Pear tree Hill Solar Farm

Response to Deadline 2 submissions and additional information

Application Document Ref: EN010157/APP/8.14
October 2025

#### Figure 3.6: Indicative Culvert Crossing Points

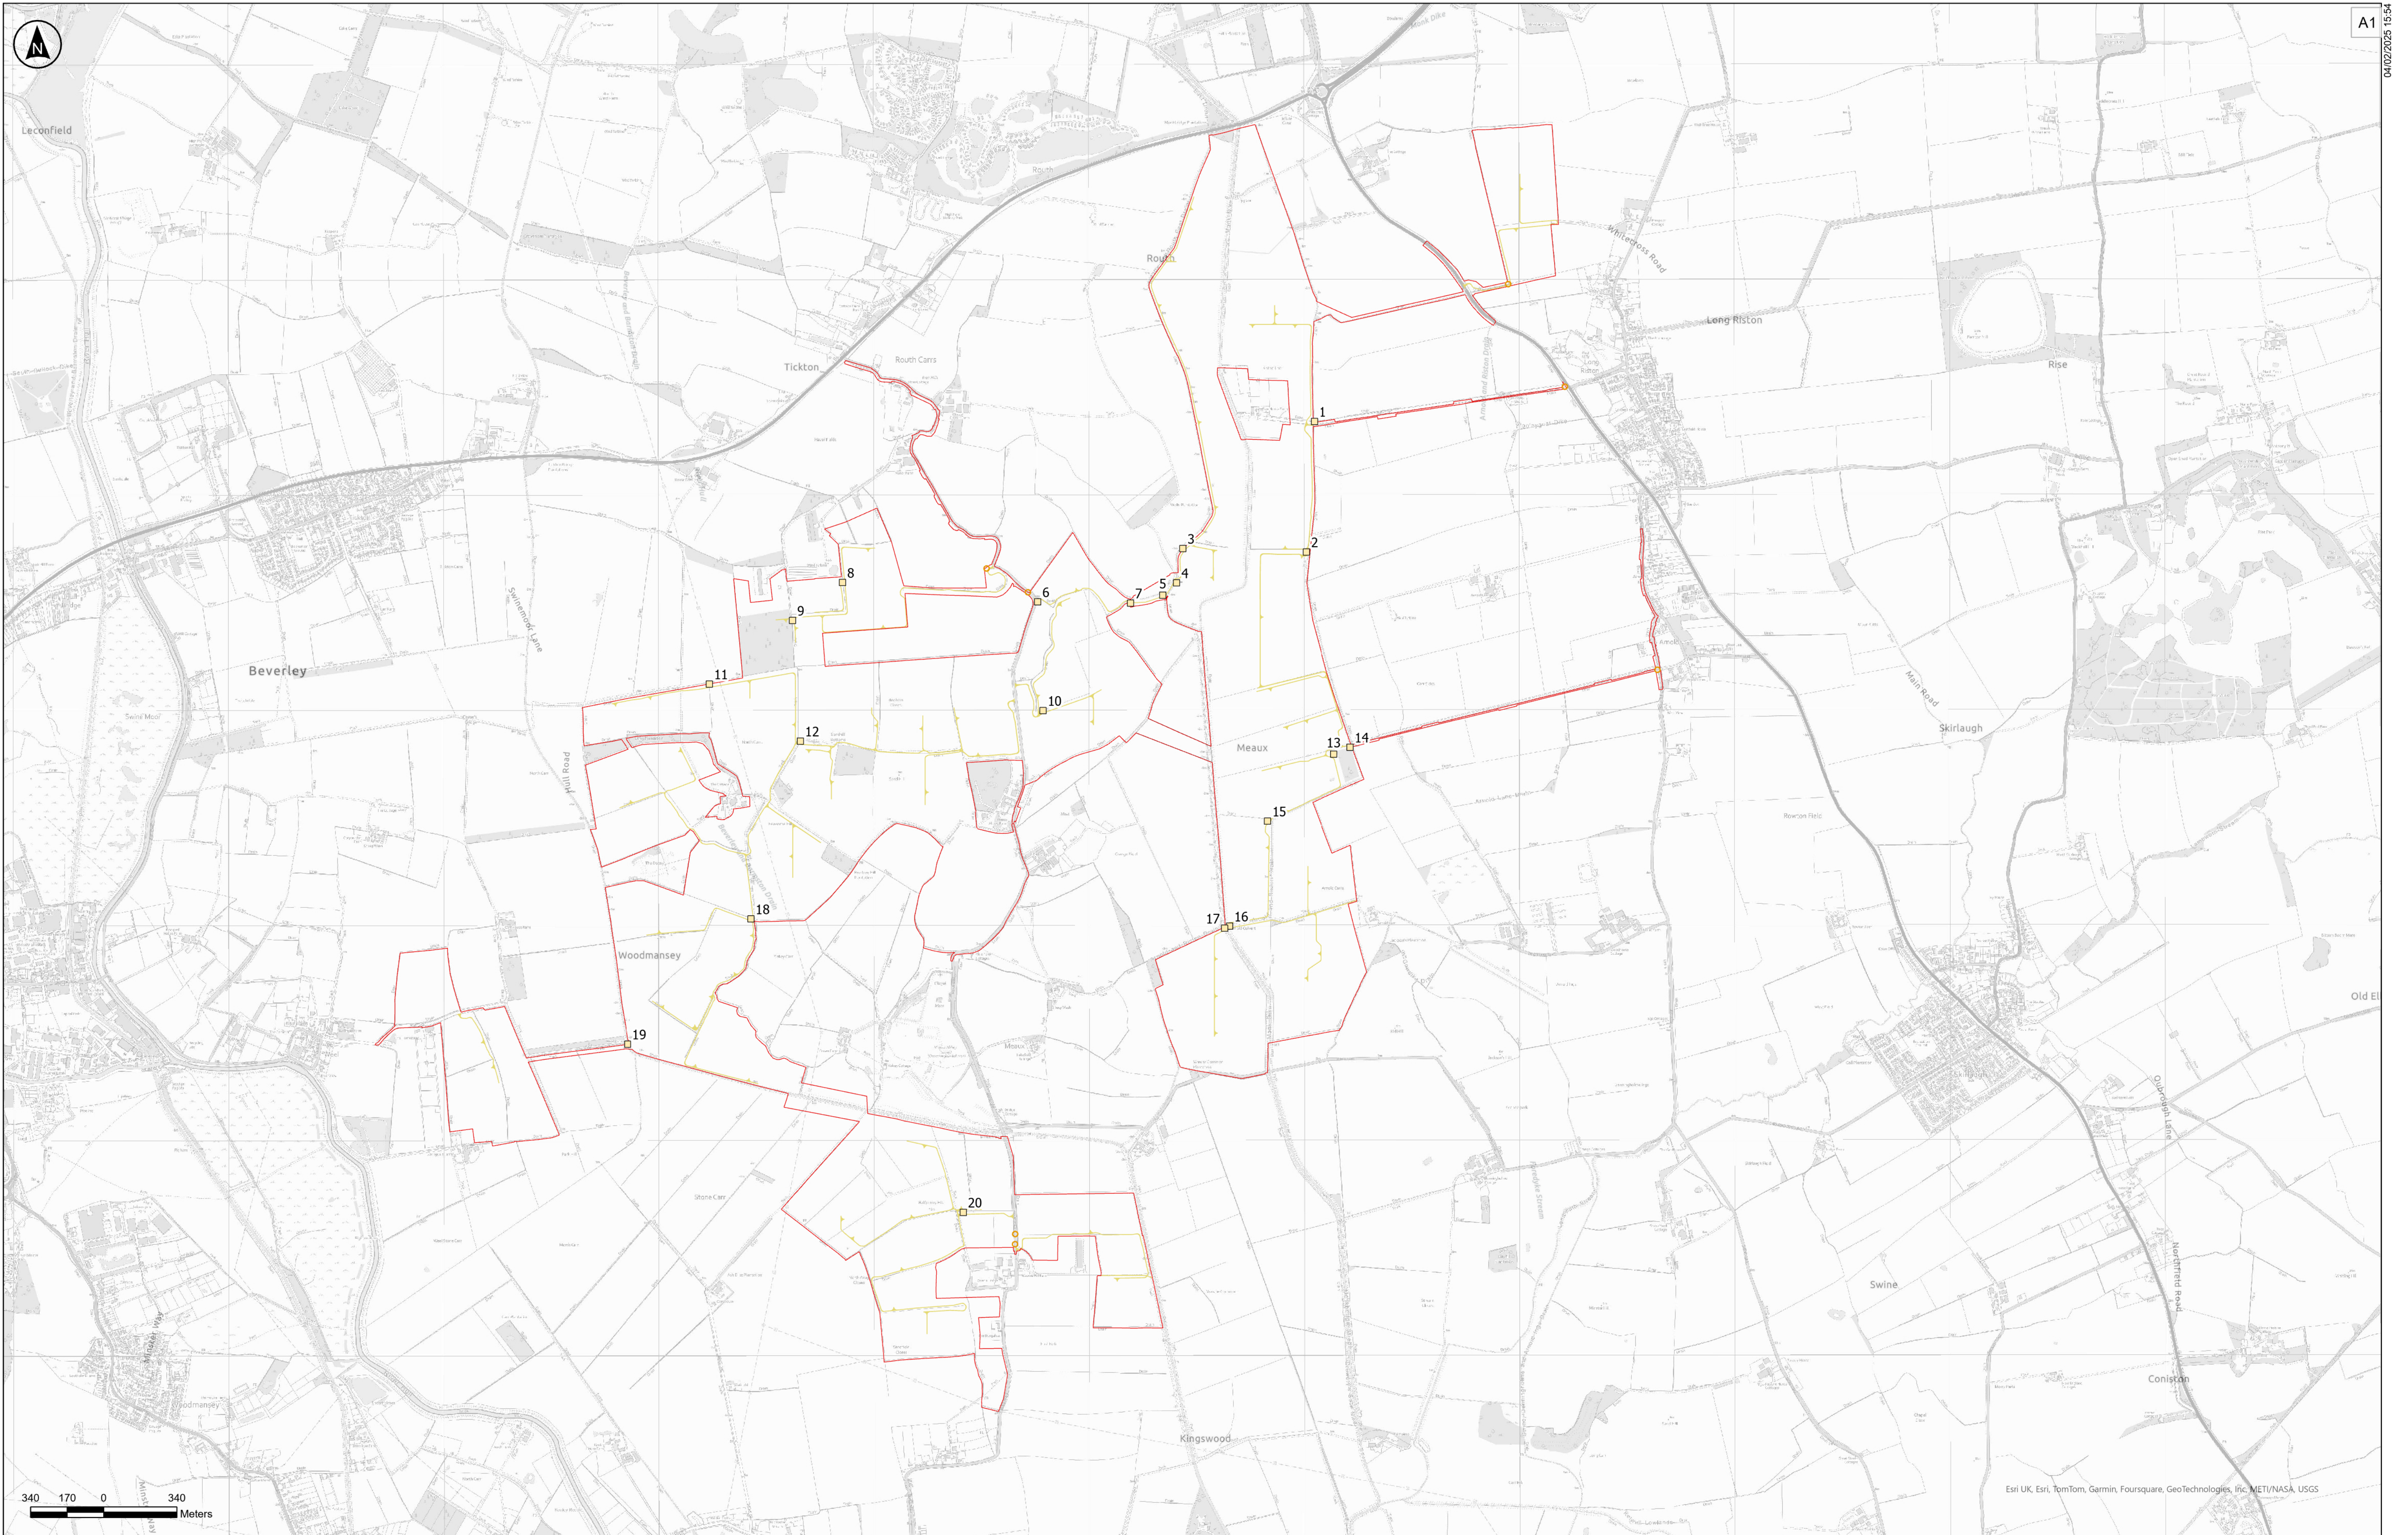
<p>EA06 – Use of culverts</p> <p>The EA raised concerns regarding the use of culverts unless as a last resort. The Applicant has responded to this point in their Response to Relevant Representations [REP1-071] (page 30). In addition, they have submitted an updated Water Framework Directive Screening & Scoping Assessment [REP1-031].</p> <p>We welcome the Applicant's intention to utilise existing culverts or bridges where possible and note that, while the actual number of new crossings is likely to be lower than the 20 assumed locations following the completion of pre-construction surveys, for the purposes of the assessment it has been assumed that all existing crossings will require a new culvert structure to</p>	<p>This response is noted and as per the Applicant's response to Relevant Representations [REP1-071], the choice of crossings is subject to detailed surveys and investigations. The preferred method will be agreed with the Environment Agency at the detailed design stage via the Protected Provisions in Part 4 of Schedule 12 to the Draft Development Consent Order DCO [EN010157/APP/3.1 Revision 7]. Box culverts were presumed to be utilised for the purposes of the assessments (such as ES Volume 4, Appendix 5.5:</p>

EA Response Summary	Applicant Response
<p>ensure consideration of the worst-case scenario. We also acknowledge commitment 109 within their Commitments Register [REP1- 029].</p> <p>However, in their response, the Applicant states that crossings over minor watercourses would be facilitated by box culverts with a mammal shelf and a bed substrate matching that of the watercourse, so no significant effects are anticipated. We are pleased to note commitment 544. As previously advised, if any existing box or pipe culvert crossings are found to be unsuitable, they should be upgraded to a portal/3-sided/arch culvert or to a larger box culvert with mammal ledge and be of a size that does not restrict the passage of water.</p> <p>There should be robust (geomorphic) reasons for the use of piped/box culverts, not just financial reasons. Minor watercourses that are wet all year can be geomorphically active and also provide refuge habitats. It is reiterated that all crossings should be considered on a case-by-case basis following surveys, not just of structural strength, but of habitat and conservation value, including geomorphological activity. We would welcome changes to the commitments to reflect this.</p> <p>In addition, while the Applicant has assessed the impacts that culverting may have on main rivers, there are some locations where there are multiple crossings in close proximity to each other. The cumulative impact of potentially culverting these rivers in multiple locations should be considered.</p>	<p>Water Framework Directive Screening and Scoping [REP1-030] to follow a precautionary approach.</p>
